Arun District Council
Arun Civic Centre
Maltravers Road
Littlehampton
West Sussex BN17 5LF
Planning General Enquiries
Tel: (01903) 737756 Fax: (01903) 730442
Dx: 57406 Littlehampton
Minicom: 01903 732765
e-mail: planning@arun.gov.uk
website: www.arun.gov.uk/planning

08 March 2018

Town & Country Planning Act 1990 (as amended)
Town and Country Planning (Development Management Procedure) (England) Order 2015
Application for approval of matters reserved by condition imposed under AL/47/14/PL relating to
condition No. 6 (Landscaping scheme), 7 (Plot boundary fences), 8 (Surface water drainage), 9
(Scheme to improve current site access) & 10 (Lighting)
Aldingbourne Farm Shop Nyton Road, Aldingbourne,

Tree and Hedge Planting

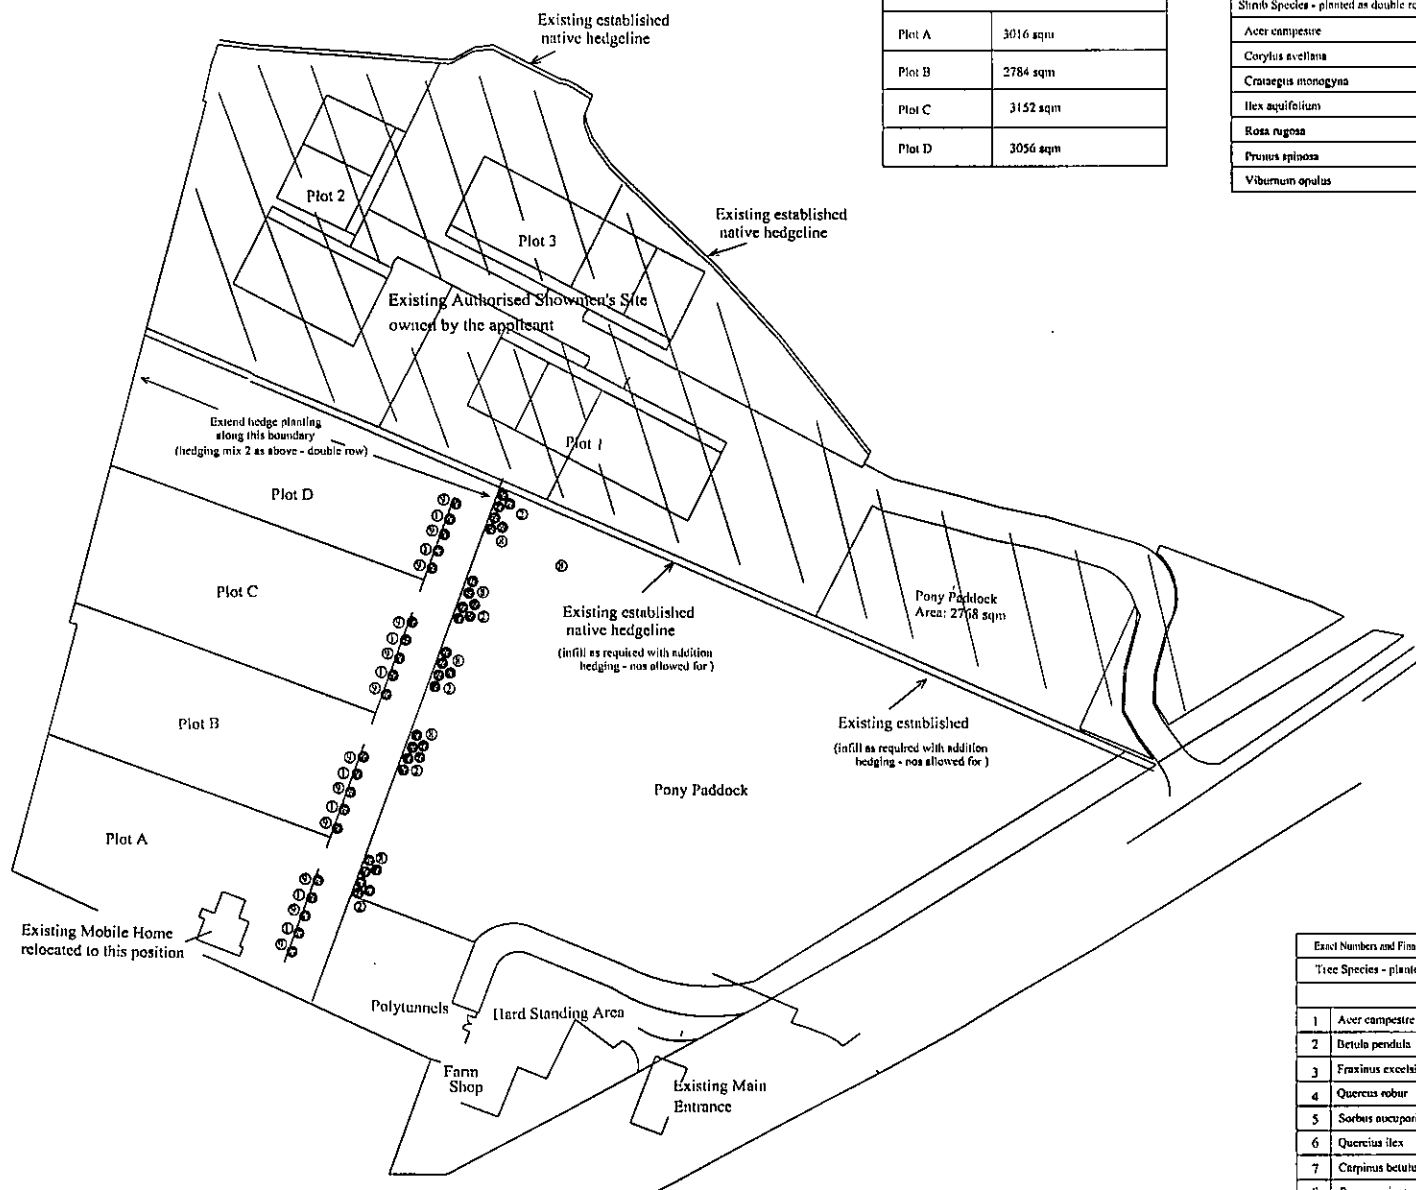
Advice received from the Councils Landscape Officer on 24/04/17 is that the submission does not provide a sufficiently detailed plan showing the location of trees and the location of infill enhancements to the existing hedging. Without this level of detail, it is not possible to agree the planting scheme. It is also requested that standard trees be incorporated along the hedge line adjacent to Plot D. The requirements of the condition are therefore not satisfied and the condition is not discharged.
